**WEST SUSSEX COUNTY COUNCIL
STRATEGIC PLANNING DIVISION**

DATE: 5th September 2011

SUBJECT: BR/148/11 – Conversion from a house of multiple occupancy into 8 self-contained apartments with associated external works. Demolition of Wee Glenlogie and the construction of 2 dwellings with parking in the rear garden. Glenlogie & Wee Glenlogie, Clarence Road, Bognor Regis.

GLENLOGIE, CLARENCE ROAD, BOGNOR REGIS
Proposals 07
May 2011

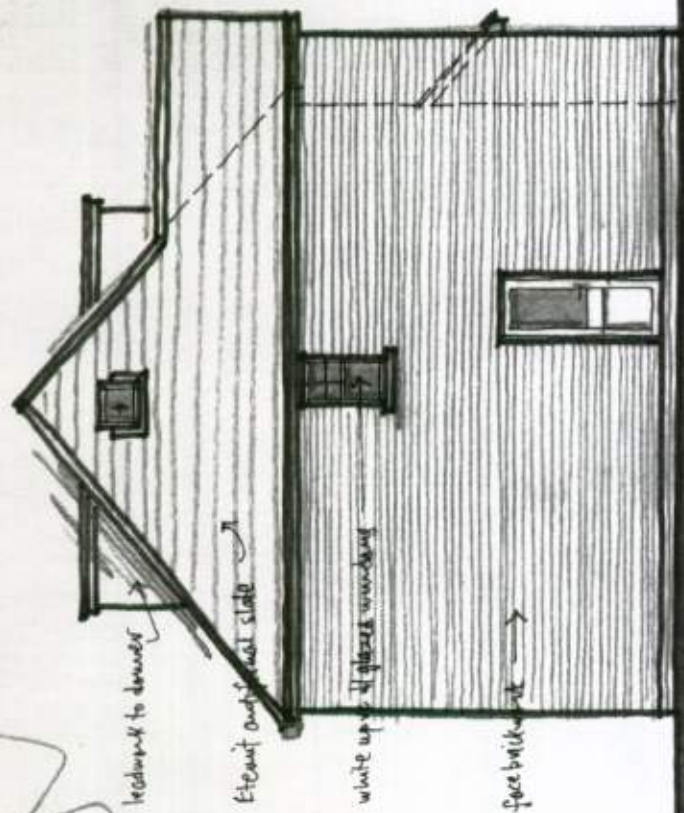
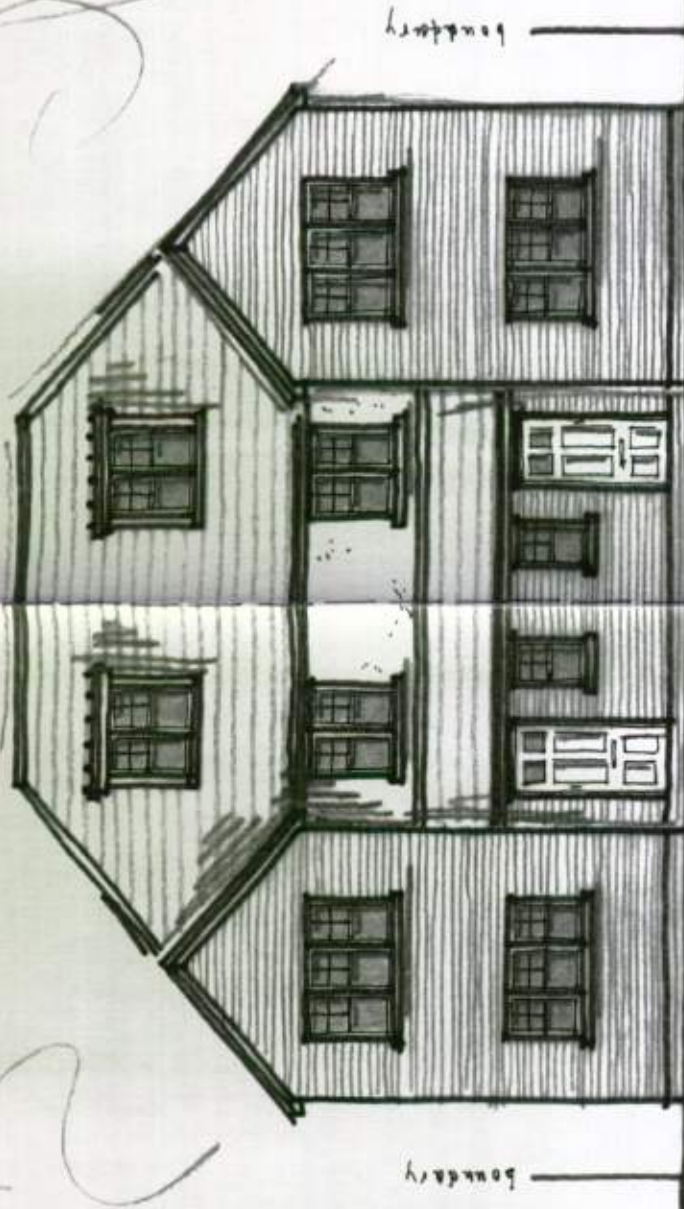
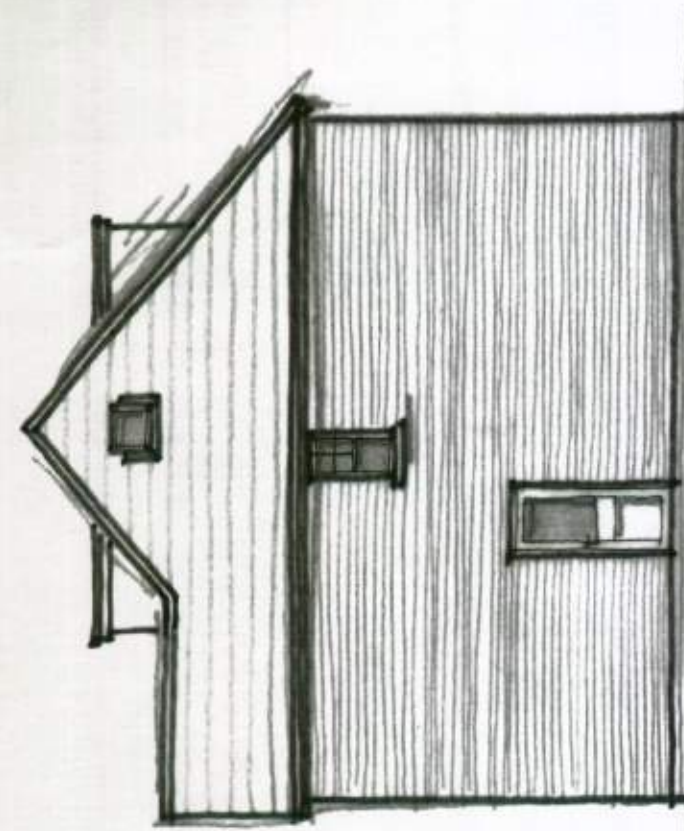
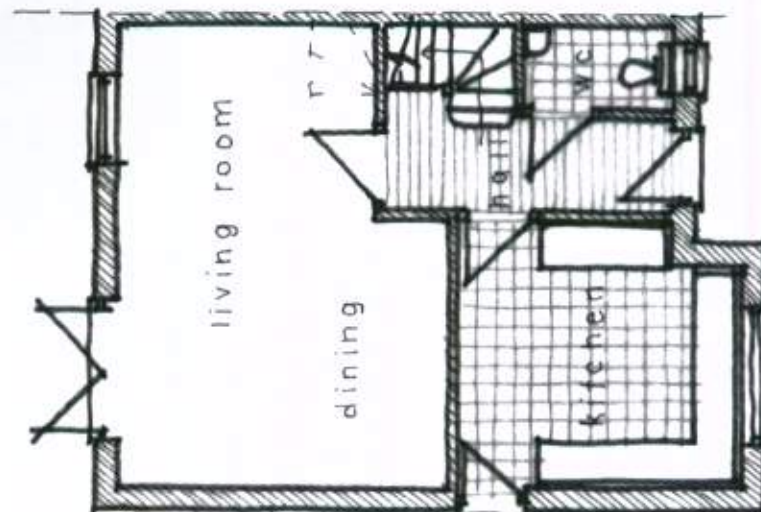
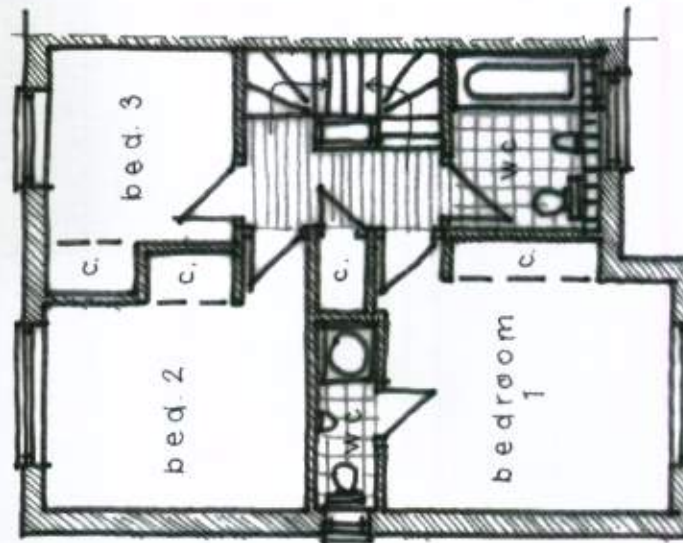
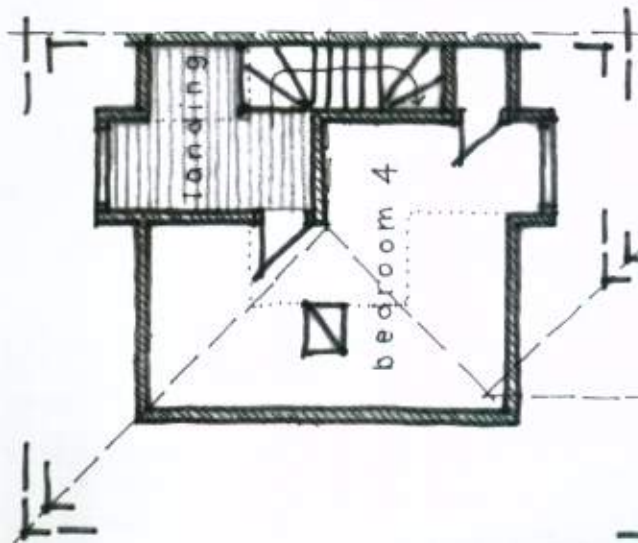
To provide an alternative to the car the applicants are proposing cycle parking as part of the Glenlogie conversion, however there is none indicated for Wee Glenlogie. Using WSCC Cycle Parking Standards the indicative level for Glenlogie would be a minimum 0.5 per flat giving a total of 4; however given the accessible location and potential pressures on parking the minimum should be extended to 1 per flat resulting in a total of 8. The cycle store would need to be secure and a condition should be imposed on any permission. Wee Glenlogie has no cycle parking indicated, and this should have a minimum of 2 spaces per dwelling (total of 4). The provision will need to be indicated on plans so that it conforms to standards.

No dwelling, hereby approved, shall be occupied until covered secure cycle parking spaces have been provided in accordance with a detailed construction plan to be submitted to and approved by the planning authority.
